Application No: EP/137/20/HH
Site Address: Outspan South Strand East Preston BN16 1PN
Description of works: Construction of garage/storage building.

Thank you for your internet representation made on 22nd December 2020 which has been recorded as an objection with the comments as follows:

Site Block Plan (1:500)

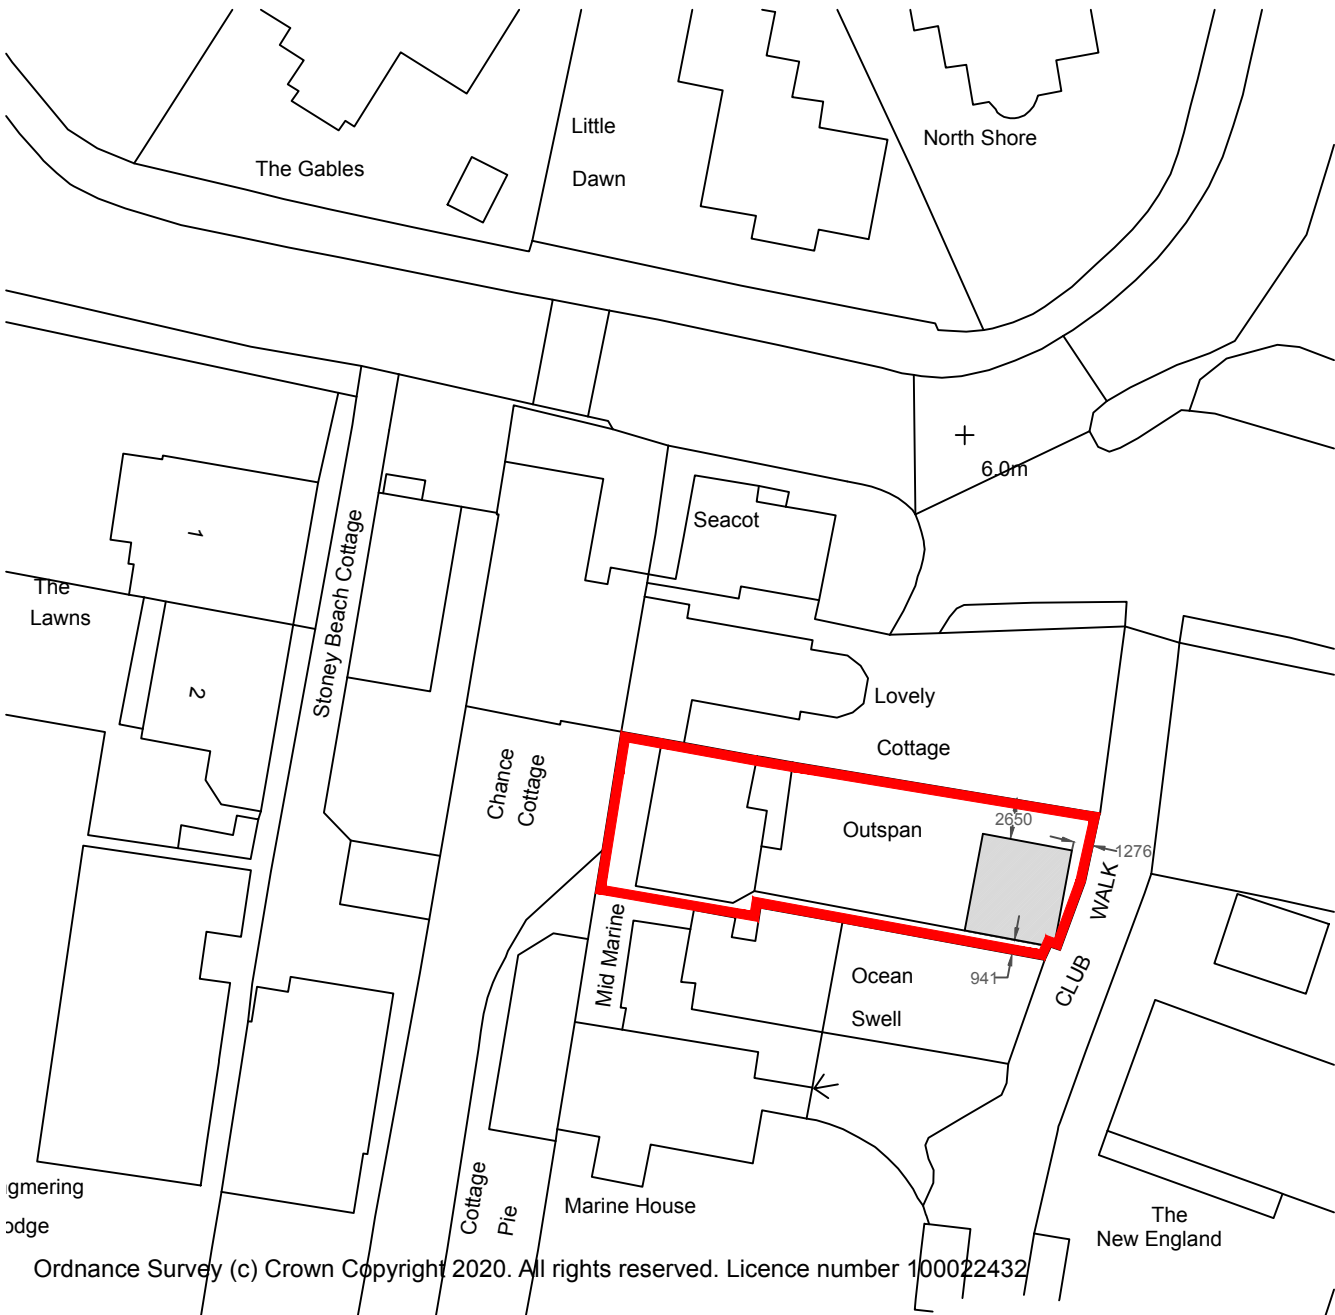
The committee also had concerns about any vehicle either reversing into the garage or reversing out of it, both manoeuvres could pose a risk to pedestrians.

East Elevation

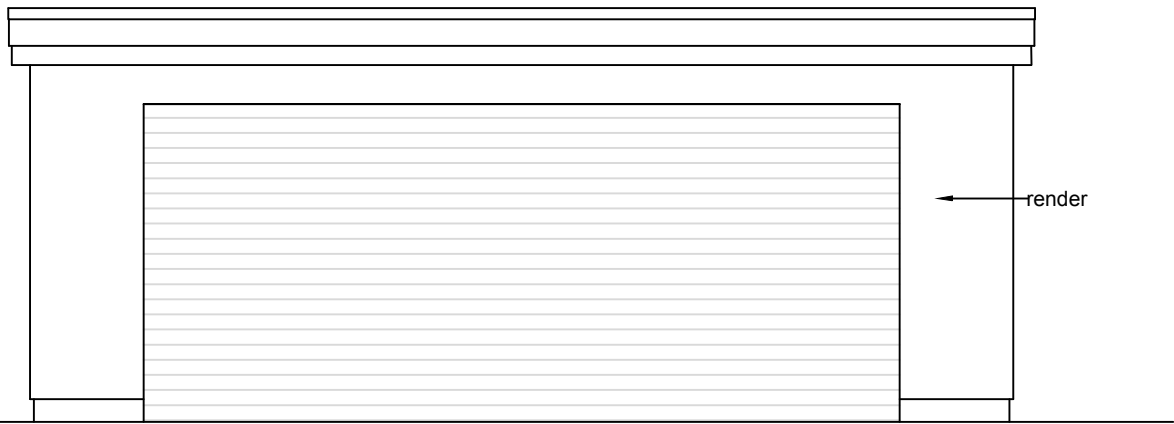
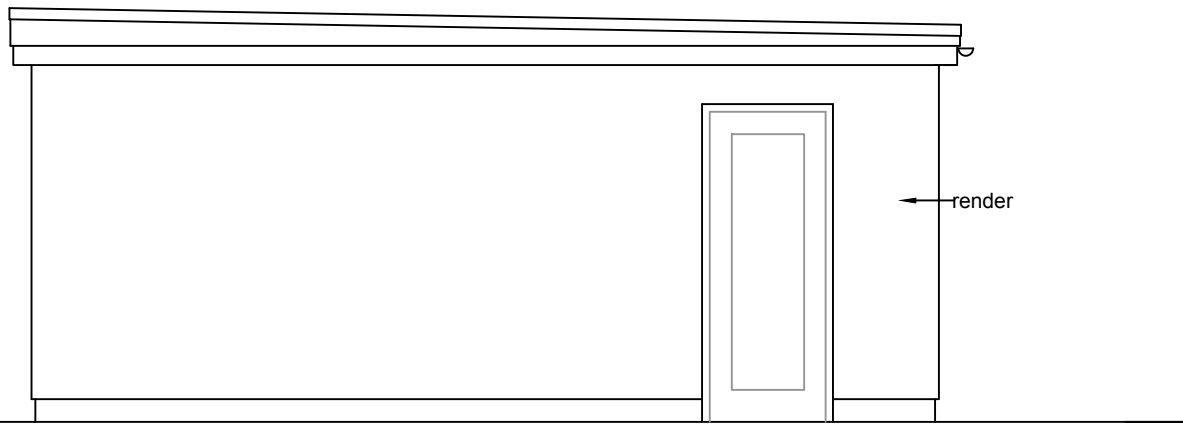
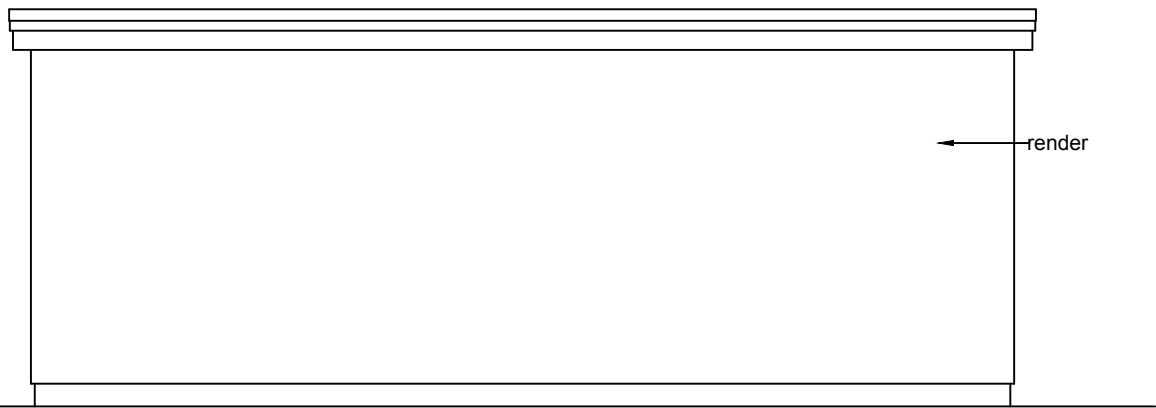
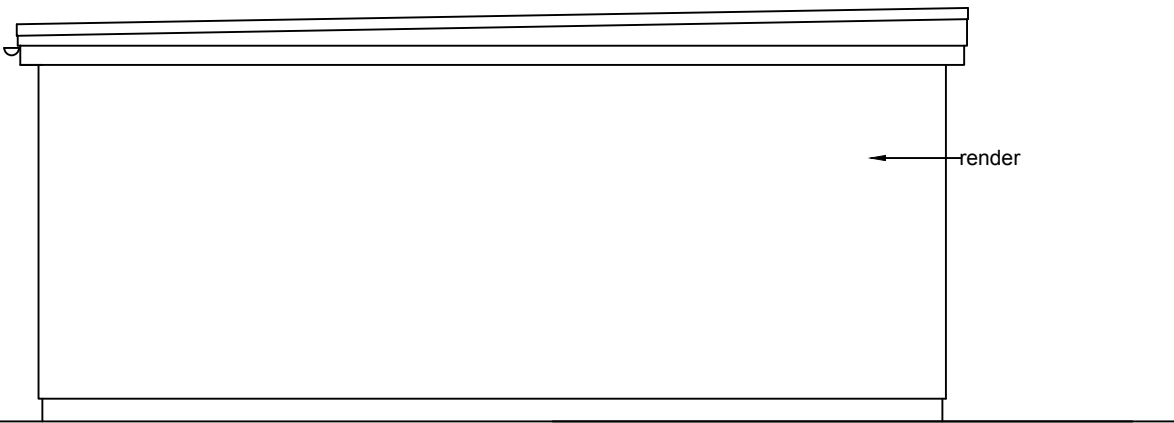
The committee agreed to object to this Application owing to the mass and scale of the proposed garage which would be out-of-keeping with this property, its garden and the footpath known as Club Walk.
